Recommendation Report for Planning Permission

REF NO: FG/179/17/PL

LOCATION: 11 Telgarth Road
Ferring
BN12 5PX

PROPOSAL: Application for variation of Condition No. 2 imposed under FG/180/16/HH to amend the design of the front elevation of the approved extension together with changes to openings on the North, East & West elevations. Resubmission of FG/77/17/PL

420.04M

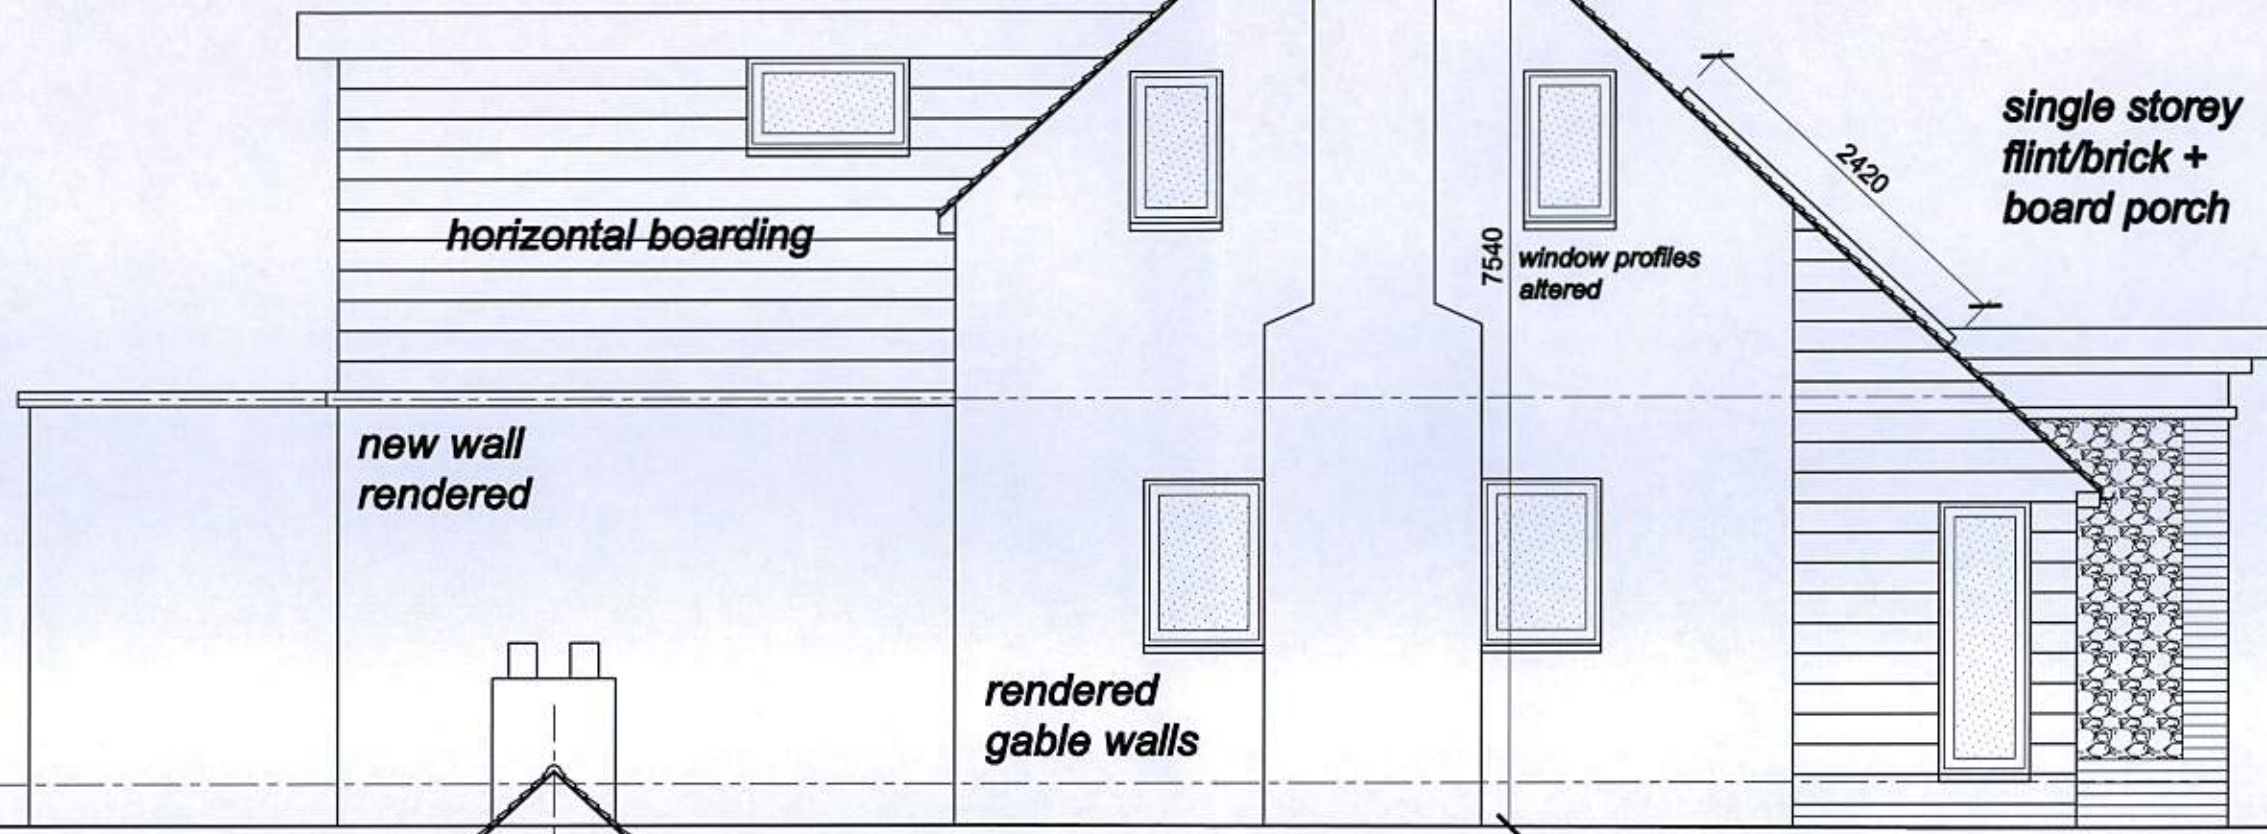
The first floor windows in the side elevations situated on the eastern and western elevations of the proposed first floor rear extension are considered to have the potential to give rise to unacceptably adverse overlooking and as such a condition has been included in this recommendation report requiring that the windows are obscurely glazed and non-opening below 1.7m. It is also acknowledged that first floor windows will be present at first floor level on the side elevation of the existing house - however, there are already windows present in these locations and as such the alteration of these windows is not

considered to result in any additional unacceptably adverse overlooking. It is considered that the overlooking generated by these ground floor windows is not unacceptable and as such obscured glazing would be excessive. Especially when it is considered that a 4m ground floor rear extension could be constructed under Schedule 2, Part 1, Class A of the Town and Country Planning (General Permitted Development) Order 2015 (as amended). It is also considered that similar levels of overlooking could be achieved through use of the existing rear garden and that this could be prevented through the construction of a 2m high boundary treatment by neighbours who felt overlooked. Therefore, no condition or restriction is considered reasonable in relation to these ground floor windows.

- 4 The first floor windows located on the eastern and western elevations of the proposed first floor extension shall in perpetuity be obscurely glazed and non-opening below 1.7m from floor level of the room in which the window is installed.

420.02H
rev H: 06.10.2017

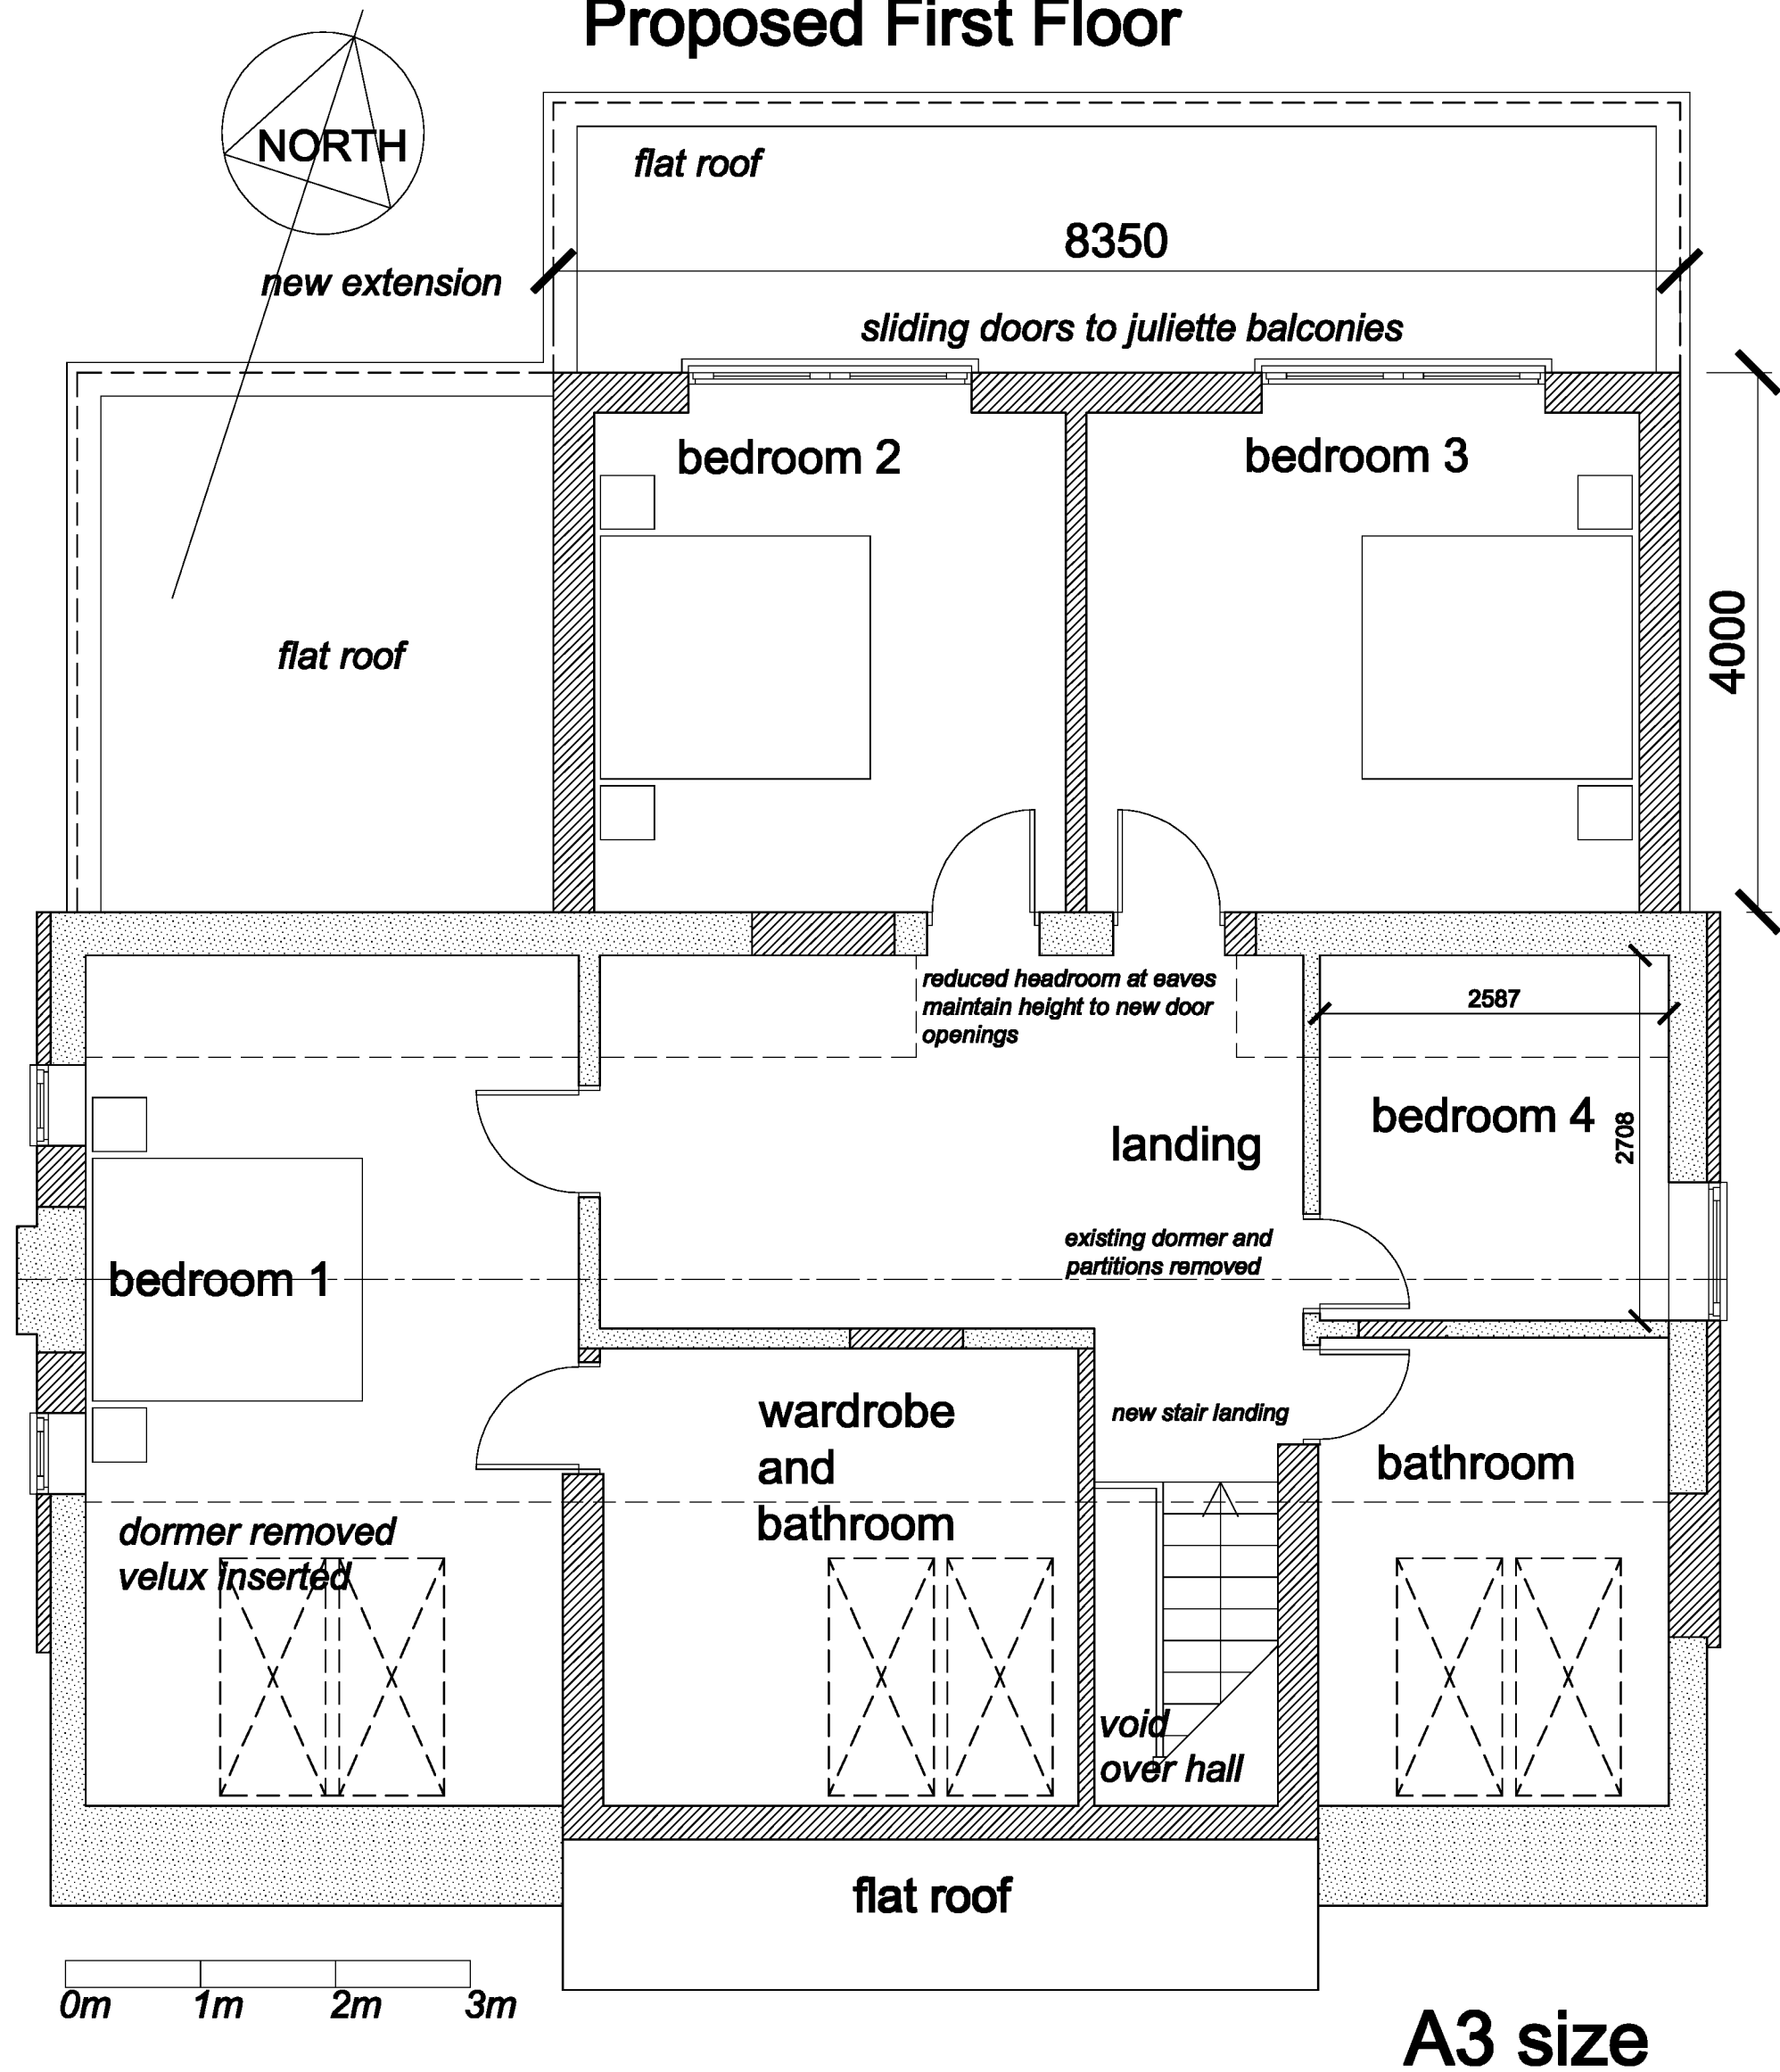
The windows on the rear elevation at first floor have been increased in size and now incorporate a Juliet balcony. Whilst, it is acknowledged that the windows at first floor level will be situated 4m closer to the rear boundary of the site the extension will remain approximately 17.5m from the rear boundary at first floor level. This separation distance is considered acceptable to prevent unacceptably adverse overlooking and is deemed to be in line with a large number of other residential developments. Whilst the windows are increased in depth the potential for adverse overlooking has not increased materially and these alterations are therefore acceptable.
